WEST SUSSEX COUNTY COUNCIL CONSULTATION

TO:	Arun District Council FAO: Michael Eastham
FROM:	Highways, WSCC
DATE:	24/05/18
LOCATION:	Land North of, Water Lane, Angmering
SUBJECT:	A/40/18/OUT Outline application with some matters reserved for the development of up to 525 residential dwellings (Class C3), 3 ha (gross) of employment land (Class B1), public open space, play areas, access, associated infrastructure and landscaping. Departure from the Development Plan.
DATE OF SITE VISIT:	20/04/2018
RECOMMENDATION:	☐ Advice ☐ Objection ☐ Modification ☒ No Objection ☒ More Information ☐ Refusal
S106 CONTRIBUTION TOTAL:	£ See below for breakdown.

ITB9105-GA-106

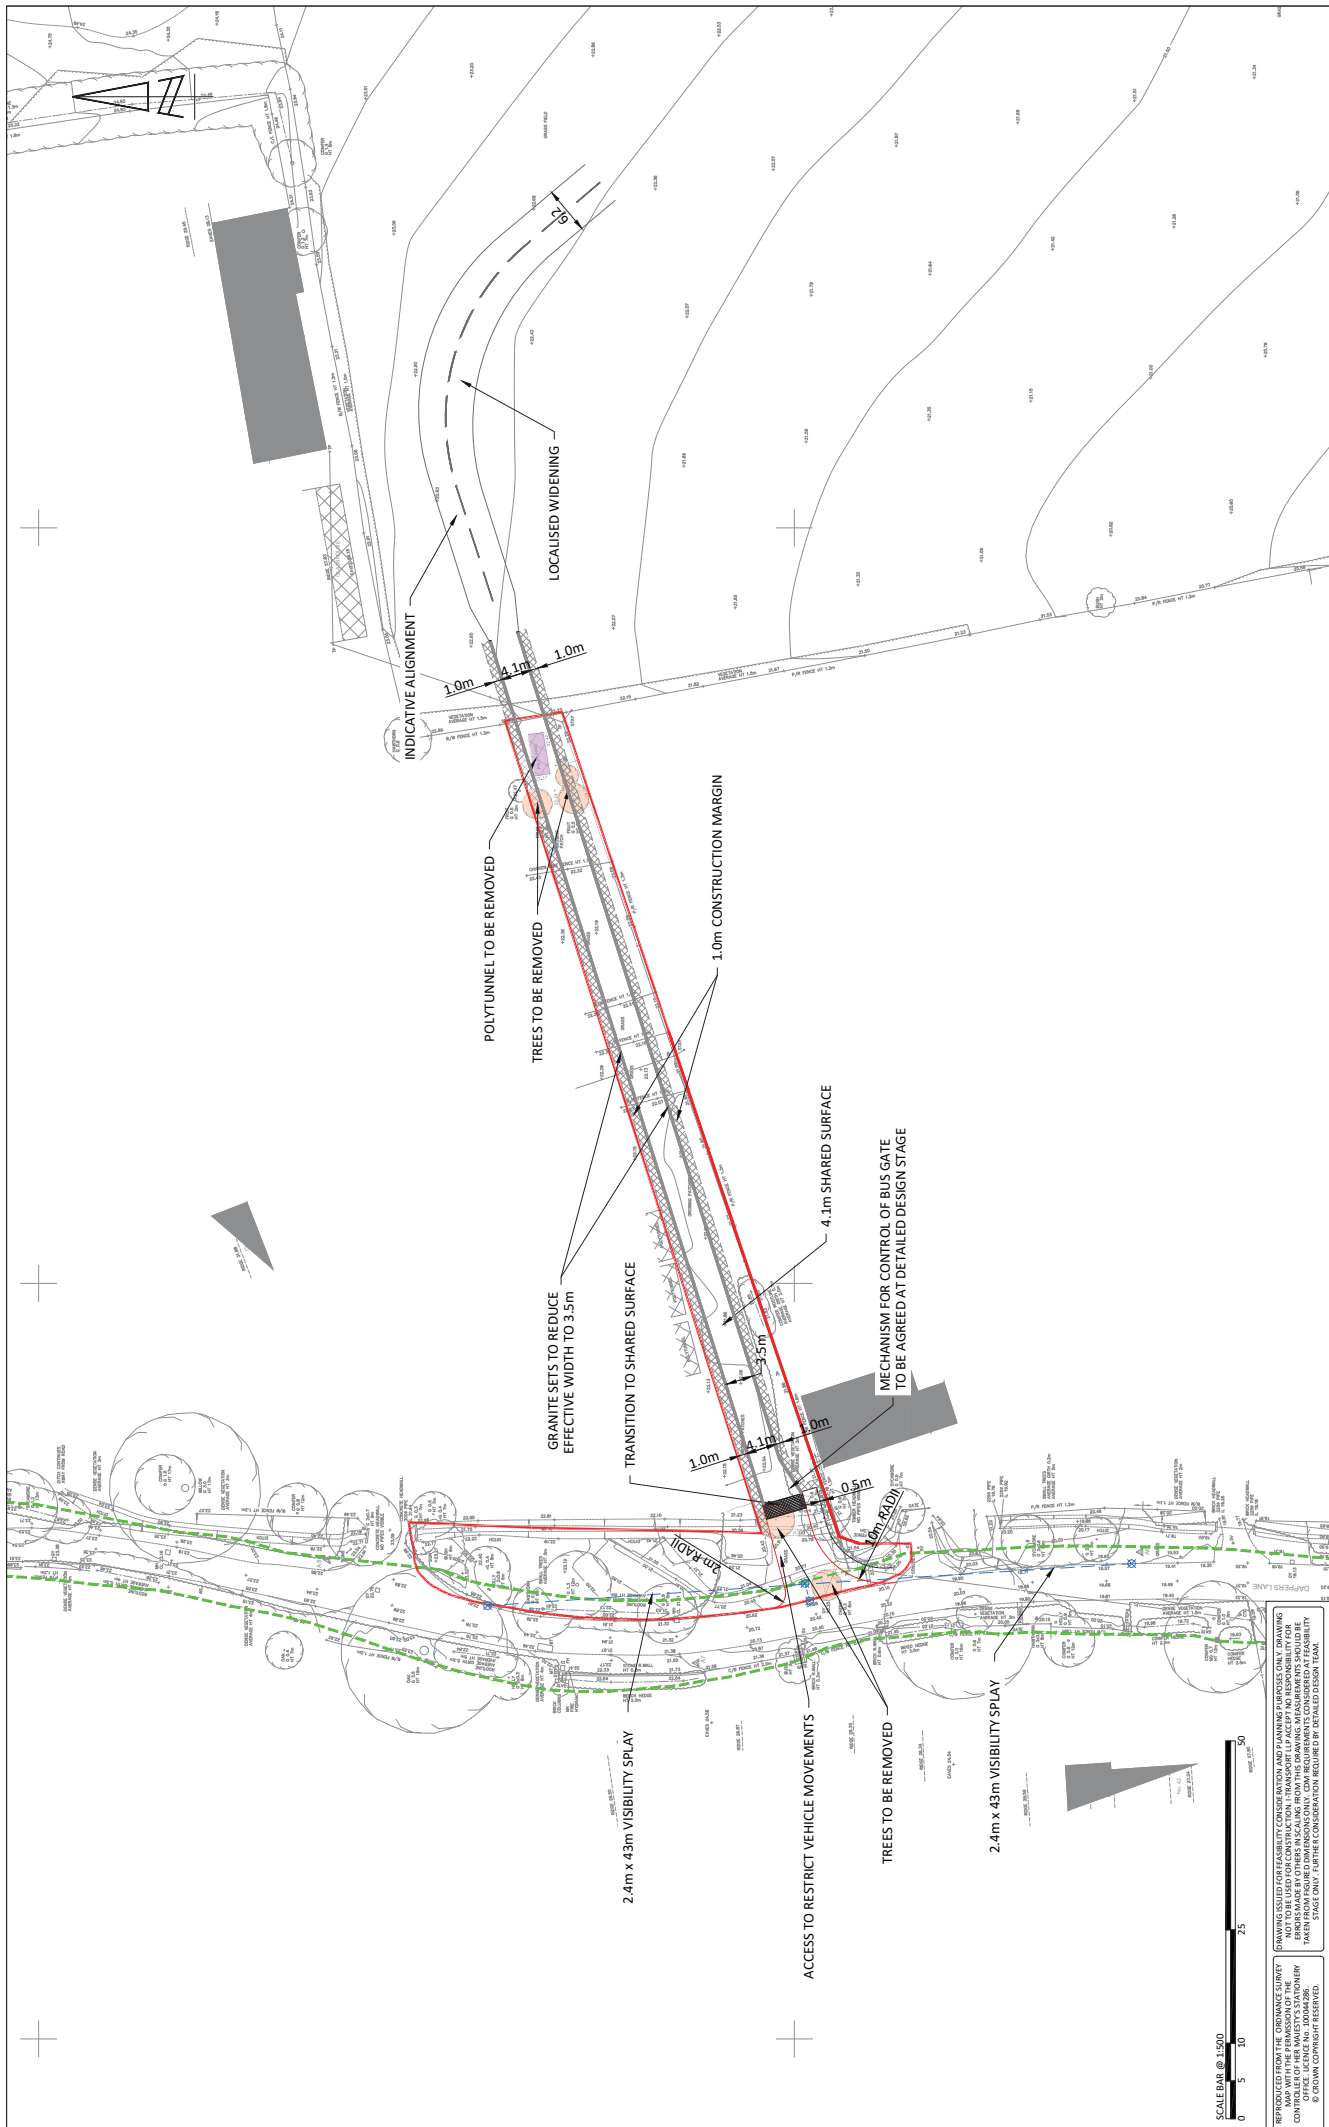
A 1.5m wide footway connection is proposed adjacent to the site access on Dappers Lane to connect Water Lane with Merryfield Crescent, shown on Drawing ITB9105-GA-106. Additional pedestrian improvements along Dappers Lane are proposed by the committed

developments of A/27/16/PL and A/142/16/OUT. Should the A/27/16/PL not commence before the south west corner plots are commenced then this application should deliver the works.

Highway works to Dappers Lane as shown on drawing no ITB 9105-GA-106
